Engineers comments on surface water drainage;

APPLICATION NO: Y/19/20/RES

Site Address: Land to the south of Ford Lane and east of North End Road Yapton
BN18 0DS

Description of Works: Approval of reserved matters following outline consent Y/80/16/OUT for 4.5ha of residential development comprising of 3.4ha of land for the erection of 100 No. dwellings (up to 30 (30%) affordable housing) together with 1.1ha of land set aside for public open space & strategic landscaping & 2.2ha of public open space & green corridors with vehicular access from Ford Lane & pedestrian/cycle access only from North End Road. This application may affect the setting of listed buildings, affects the character & appearance of the Church Lane, Yapton Conservation Area & affects a Public Right of Way.

PROPOSED DEVELOPMENT PLAN

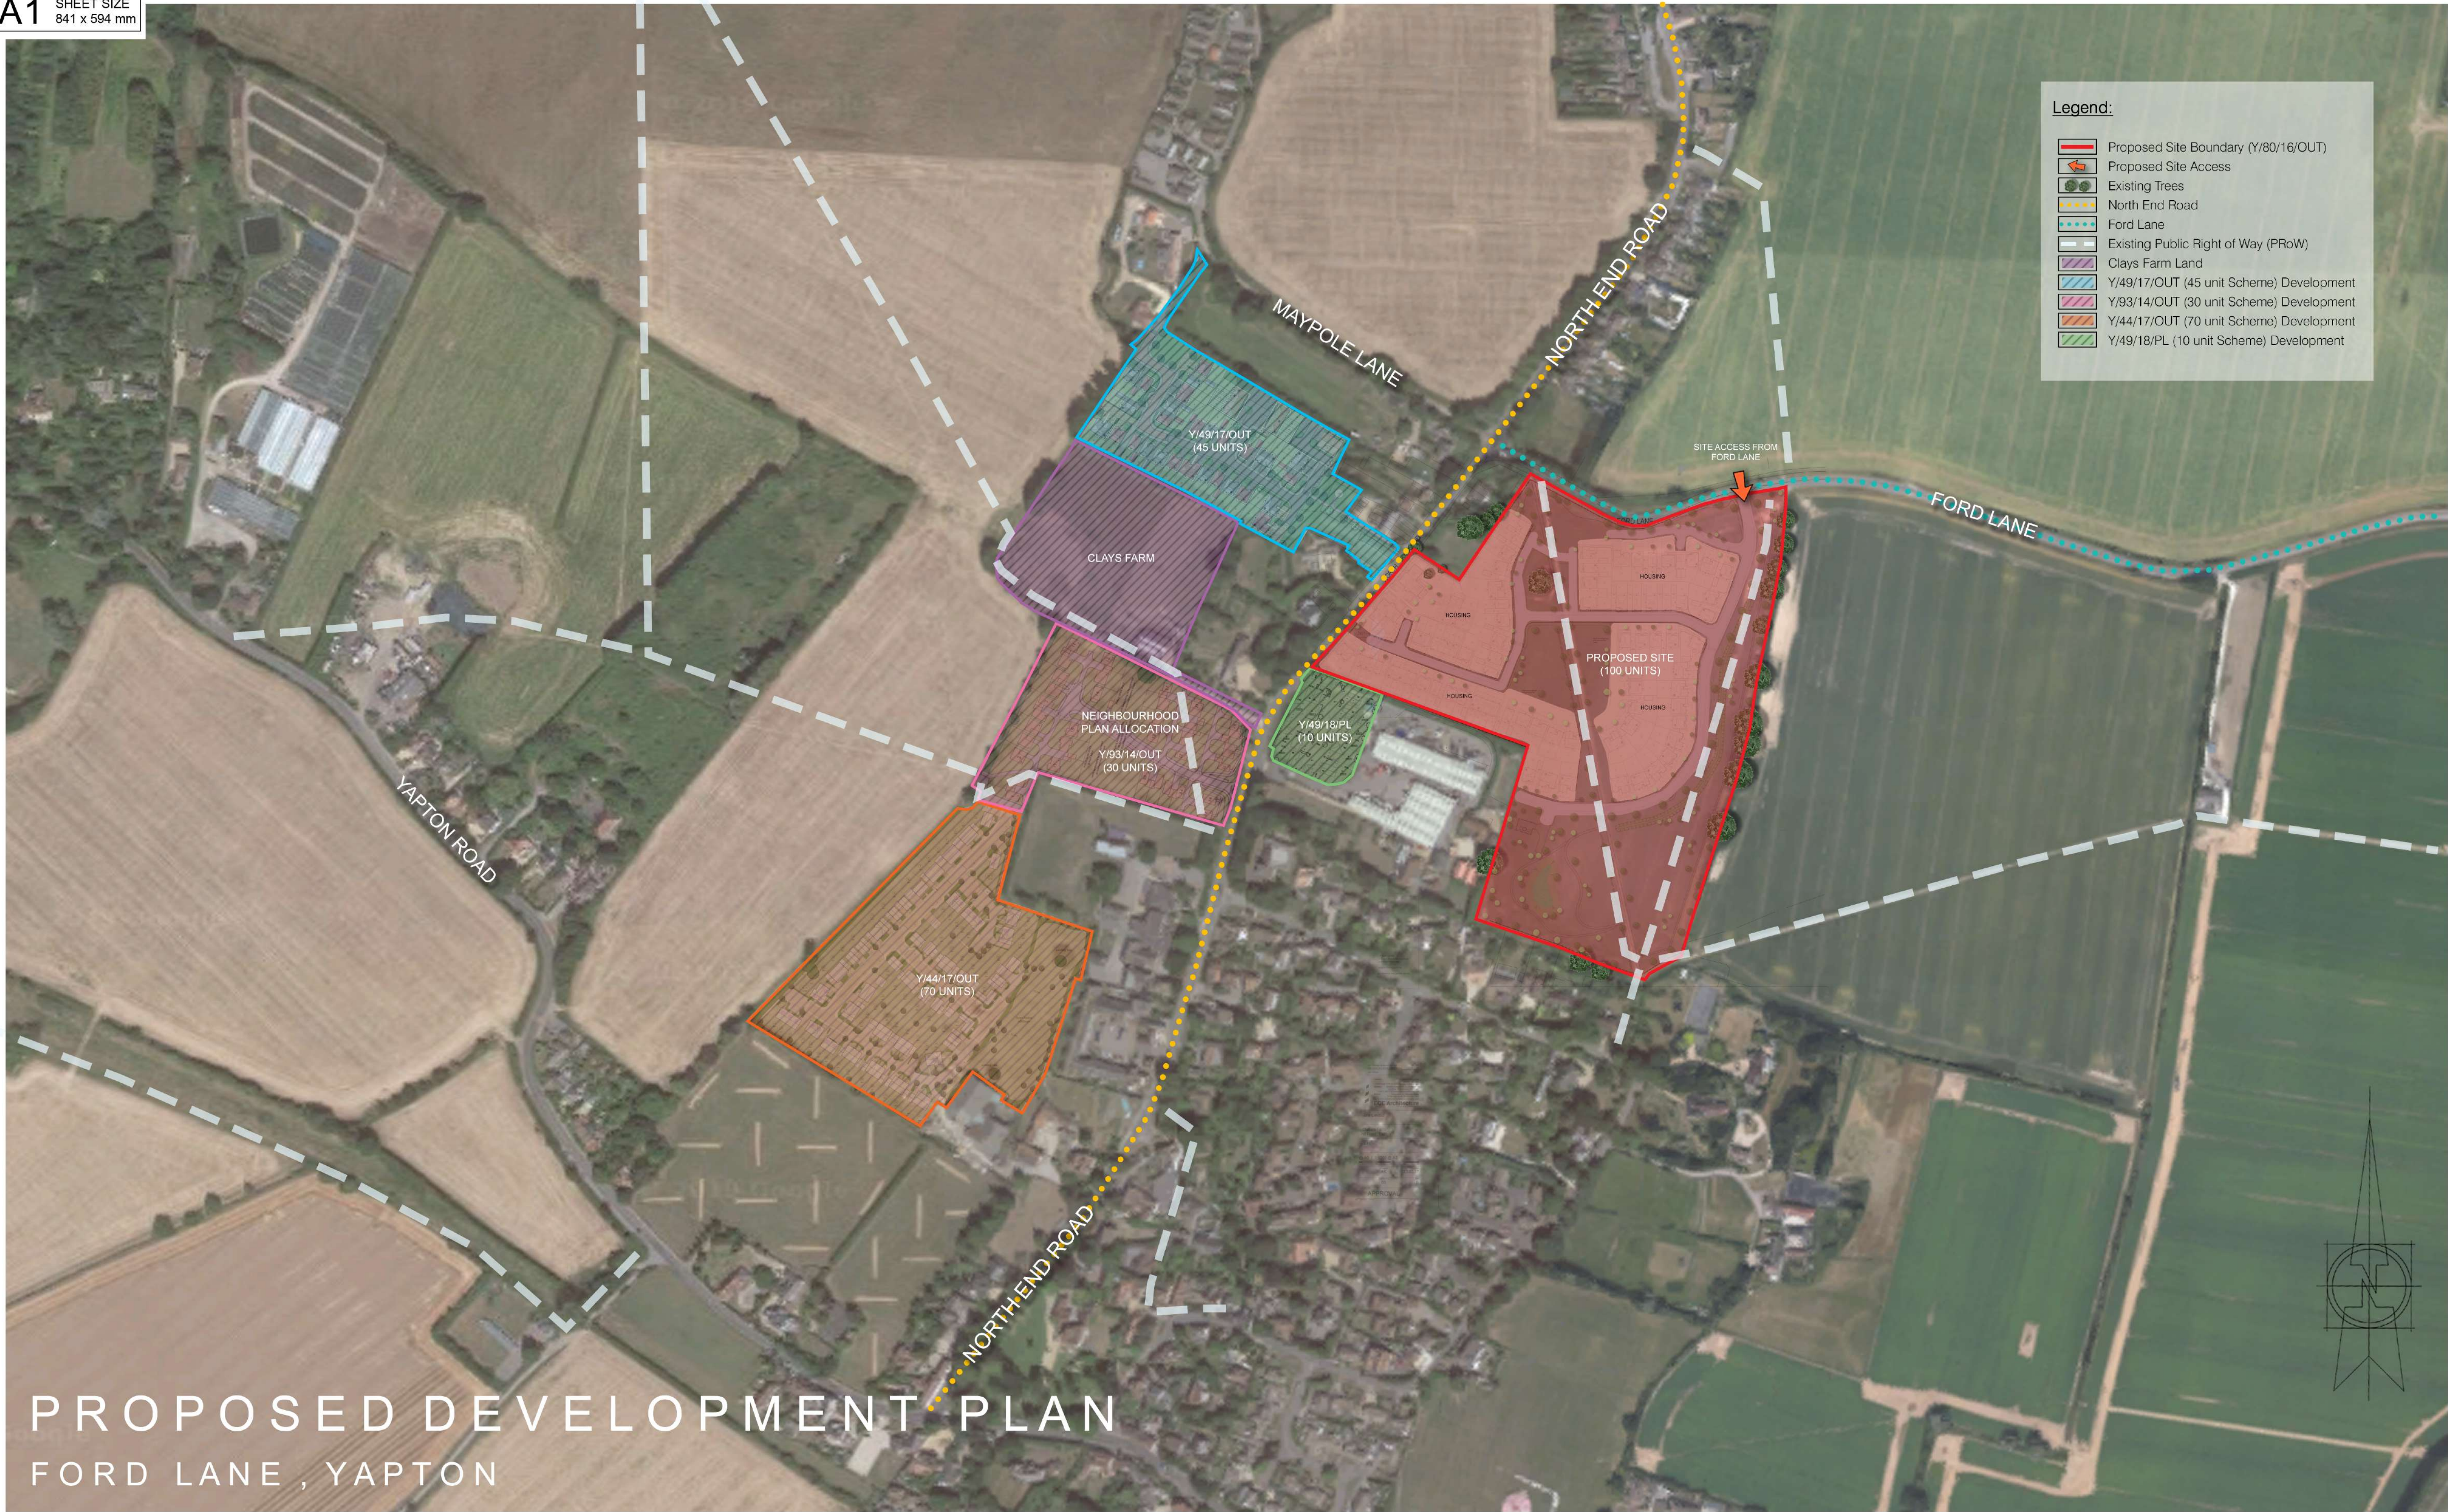
However, from the findings to date, infiltration is expected to be viable in some form. The layout presents significant open spaces to accommodate drainage features and these should be open features wherever possible ie. where crates are proposed, the viability of open features needs to be investigated. Please note that open drainage features are not counted towards the open space provision.

The applicant should note that permeable paving will need to be extended for use in all private driveways to maximise water treatment potential.

The assumed ditch on the eastern boundary has had sufficient space left beside it for future maintenance and is likely to require maintenance works to it as part of the development of the site. Its full extent will need to be investigated in order to determine the presence of any culverted sections at the northern and southern ends. This will then require further discussion.
